Subject: FW: AL/20/18/OUT - Land at Bridge Cottage & The Old Cottage, Lidsey Road

Technical Note

The Old Cottage Lidsey

1.1 Reeves Transport Planning has been commissioned to provide a Technical Note addressing the questions raised by West Sussex County Council (WSCC), acting in their capacity as the Local Highway Authority, in respect of planning application AL/20/18/OUT. The application concerns the erection of up to 27 dwellings with an upgraded access.

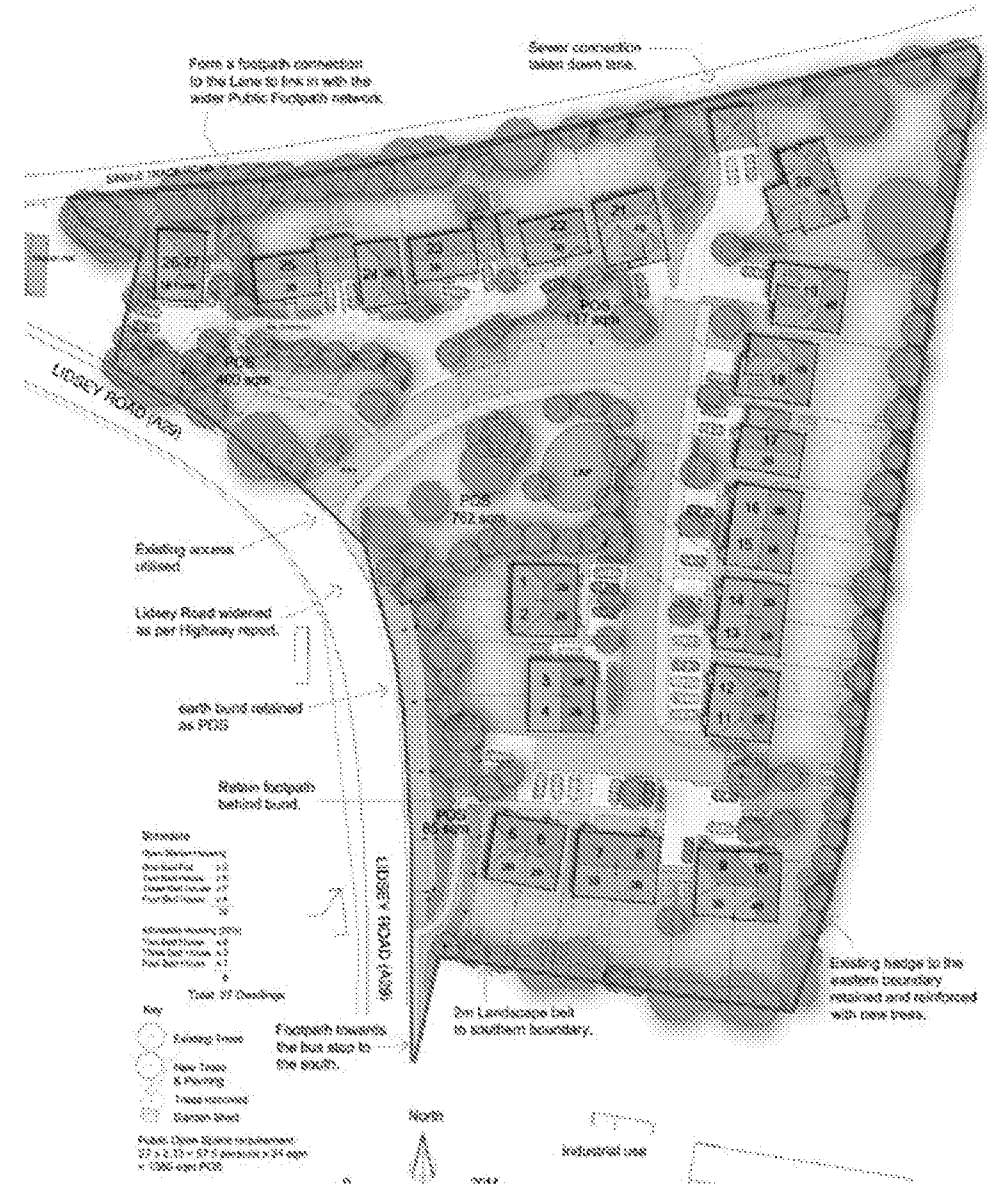
The internal layout is shown indicatively on drawing 1749-02B. As submitted, it would not be suitable for adoption under S38 given lack of suitable service margins. Also, it is not known what form of surface water drainage is proposed for the site which might itself dictate whether the layout can or can't be adopted.

With regard to access by refuse and fire appliances, the access drive shown to plots 22-27 might need widening as in places it looks slightly restrictive (particularly adjacent to plots 25-27). As such, this would have to be considered further at any RES/DOC stage.

SITE ACCESS LAYOUT PLAN – DESIGN_SGR_110216_V5

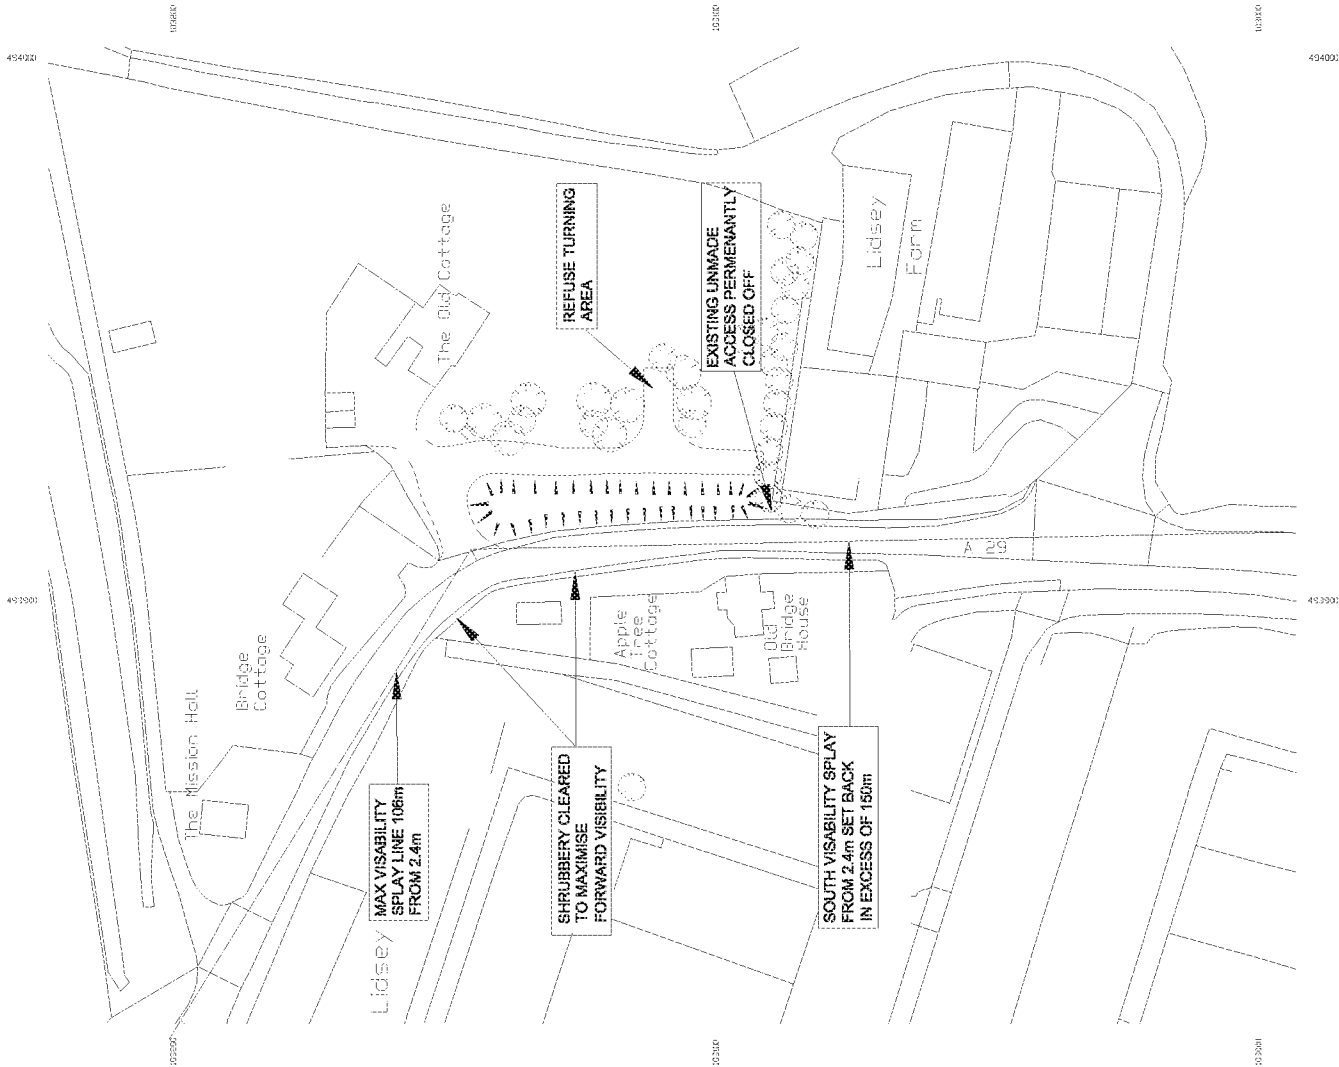
As mentioned above, vehicular access is shown directly off the A29 on the apex of a bend in the road. The access measures 4.8m wide with what appears to be 5.0-6.0m bellmouth radii (this should be clarified and marked-on a plan). Visibility splays are taken from a 2.4m 'x' distance with major road ('y'), with the applicant's Transport Consultant stating that splays of 106m in the leading traffic direction can be provided - looking west from the access - (98m scales on the plan) and 150m in the trailing direction - looking south - (79m scales on the plan). Forward visibility (i.e. that required for drivers of vehicles turning right and left into the site and corresponding visibility for drivers already on Lidsey Road coming-across them - from both north and south) is stated as being 81m (although approximately 60m scales from the drawing between a right turning vehicle and driver of a vehicle travelling southbound). No northbound forward visibility splay is shown for vehicles driving northwards coming across a vehicle turning right into the site.

Given the lack of clarity including lack of marked-on dimensions and visibility splays - it is not known what can actually be provided - both on and off-site. For the CHA to consider the matter further, the above matters should be attended to - a summary of which is provided below (other requirements are summarised elsewhere in this report under relevant sections):

- The dimensions of bellmouth radii of new junction
- The achievable visibility splays taken from 2.4m 'x' distance with dimensions marked-on
- The forward visibility both for vehicles travelling north AND south encountering a vehicle waiting to turn into the site with dimensions
- Dimensions of carriageway at and on the approach to the site entrance (and site entrance itself)

The audit team makes three recommendations based on correspondence from Reeves Transport Planning and specifically Drawing No. LID/SR/101 - all to do with the access position and visibility available to and from it. The designer accepts these although in the absence of revised plans showing specific visibility splays (see comments above), it is not possible to comment further at this stage. All that will be said is that the applicant should look at the highest 85th %tile speeds recorded and – subject to confirmation of weather conditions and as a consequence any wet-weather adjustment (if deemed appropriate) - and base visibility splays on those. Also, the RSA was based on a previous proposal for 6-7 units – not the 27 now proposed.

2.1.1 Updated plan (OCL/SR/701 Rev. No. C) is attached, as Appendix 2. The drawing incorporates dimensions of the new access, carriageway widths, and forward visibility.

2.3.1 Updated plan (OCL/SR/701 Rev. No. C) shows the visibility splays, vegetation that falls within the limits of the adopted highway that can be cleared to further enhance forward visibility, and roads markings. Any minor amendments to the access configuration can be addressed as necessary via the Stage 2 Road Safety Audit.
